CITY OF ALBUQUERQUE

November 14, 2018

RE: **Nuevo Atrisco- North Tract
Central and Unser NW
Grading Plan Stamp Date: 10/29/18
Drainage Report Stamp Date: 10/29/18
Hydrology File: K10D058**

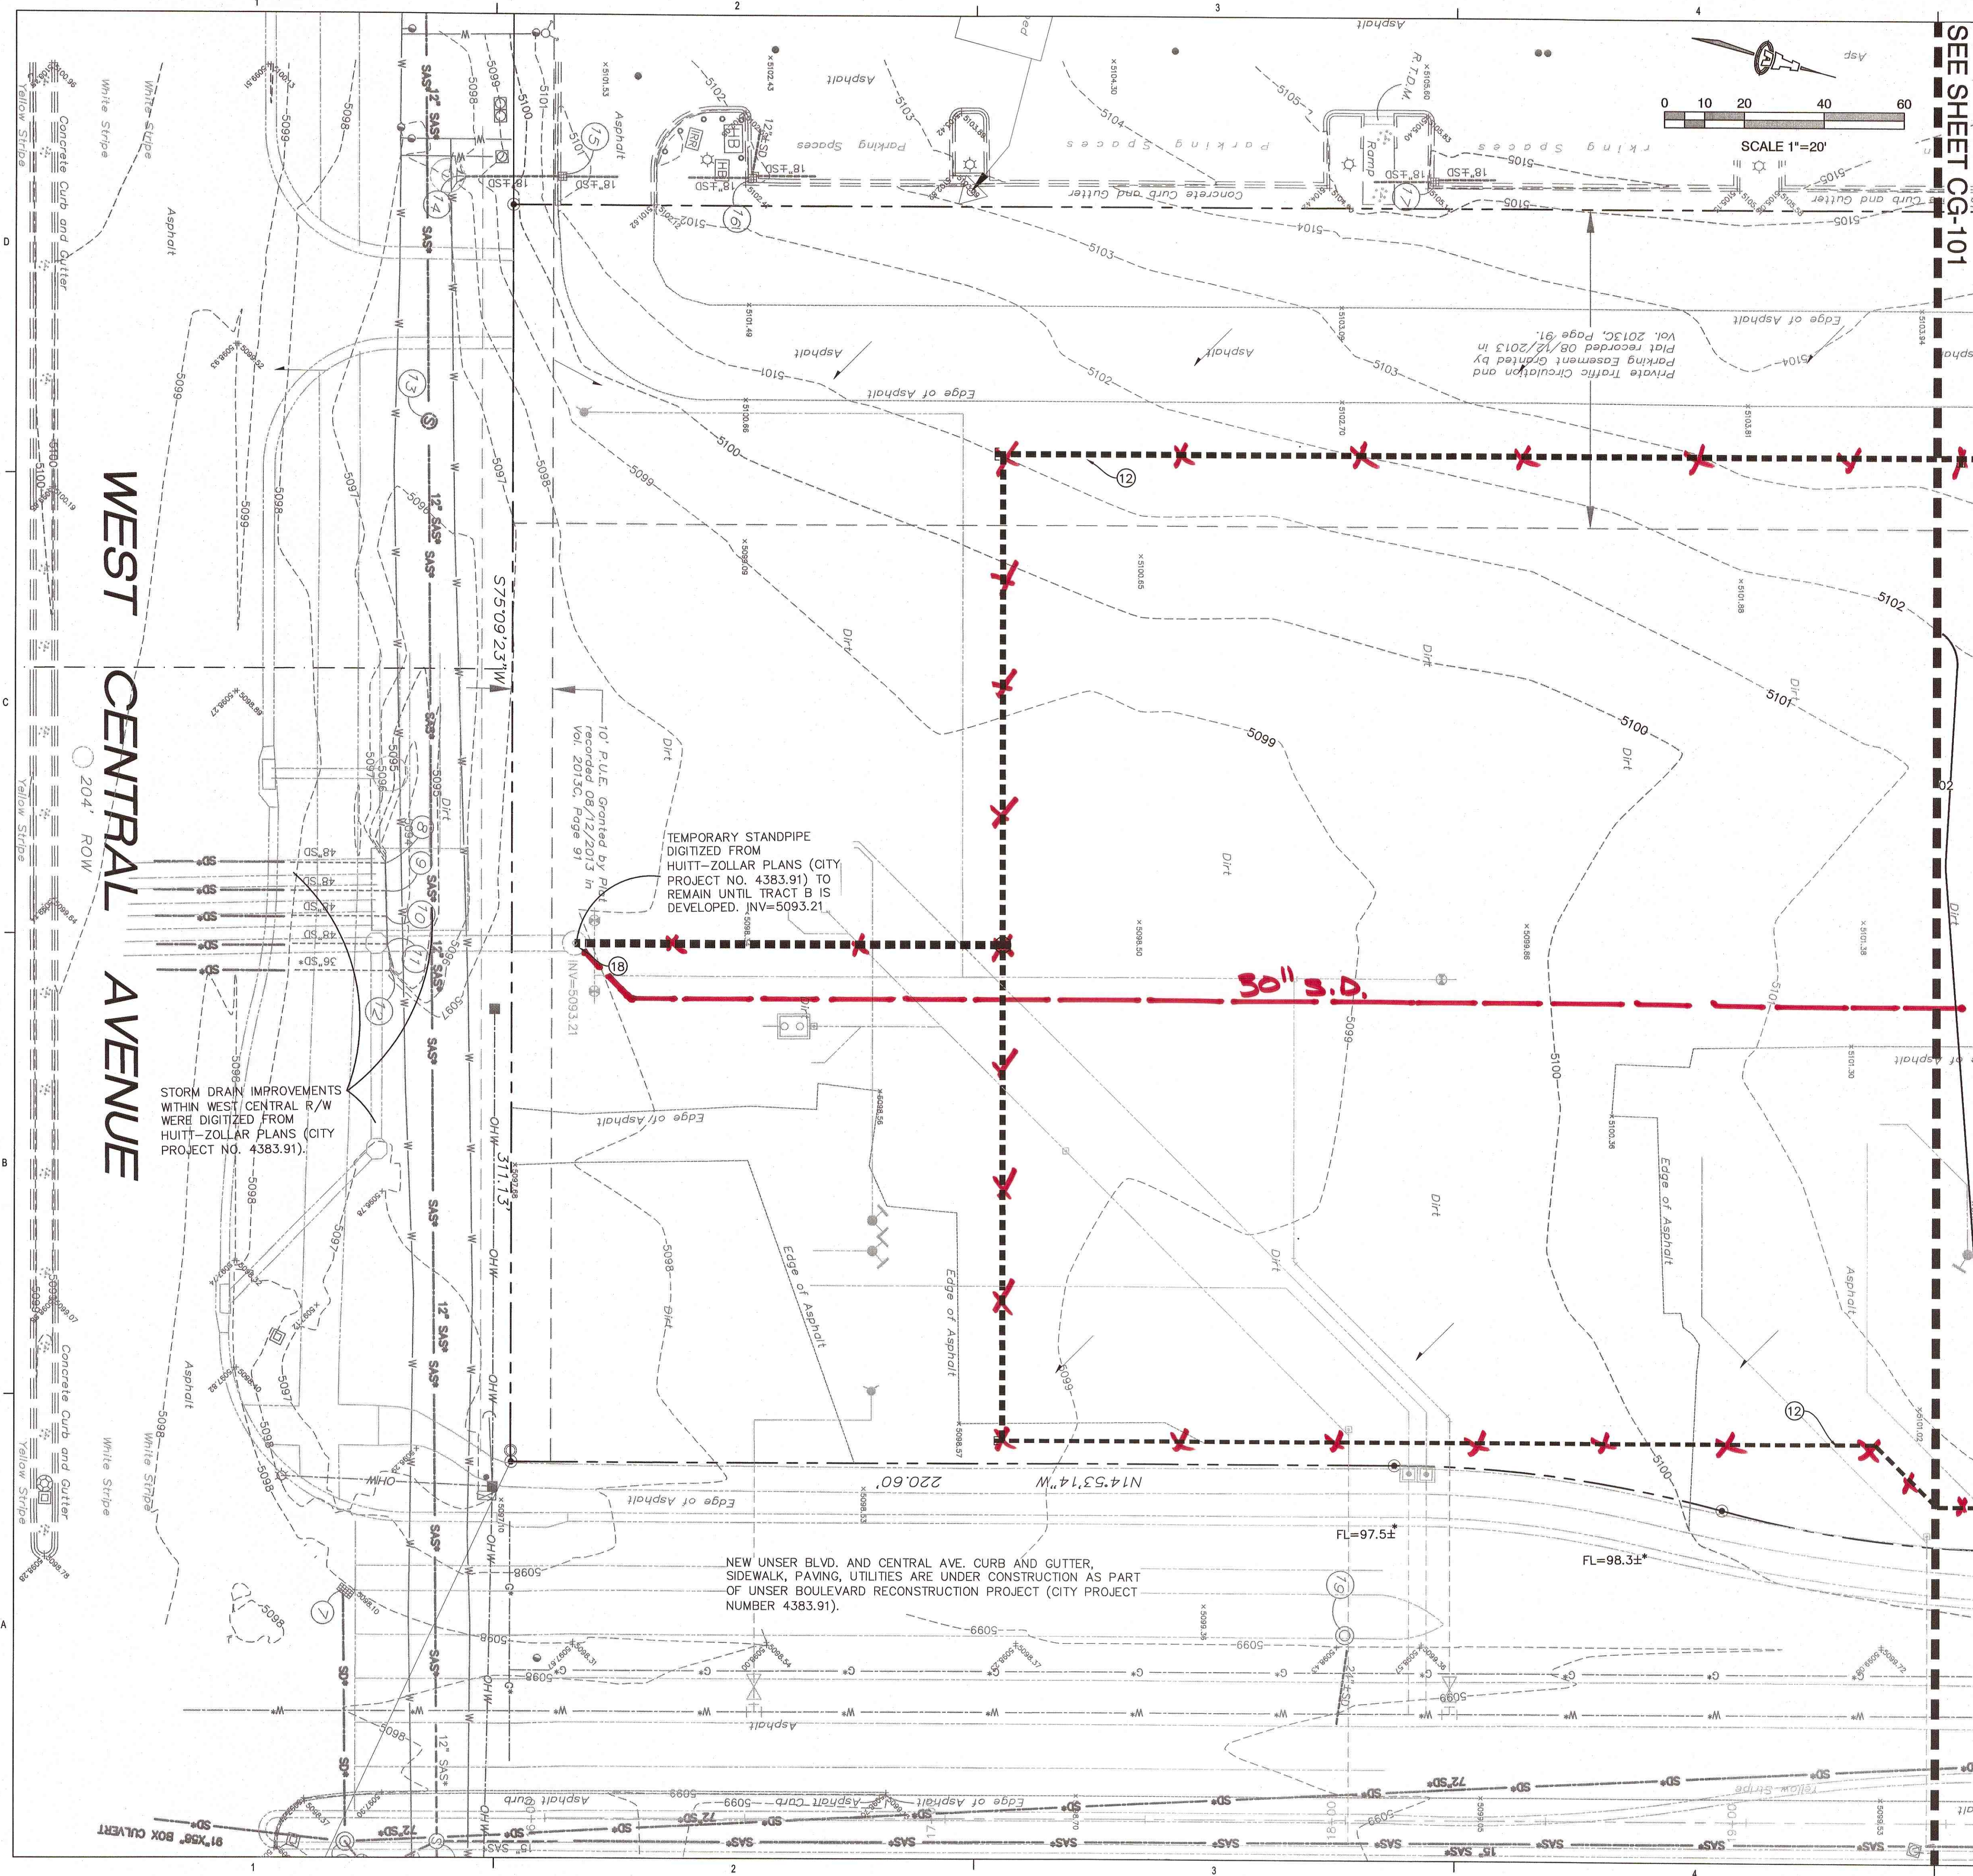
6. Where are the pipe drains (keyed note 11) located? These are not called out on the plan.
7. This project requires an ESC Plan, submitted to the Stormwater Quality Engineer (Curtis Cherne PE, ccherne@cabq.gov or 924-3420).
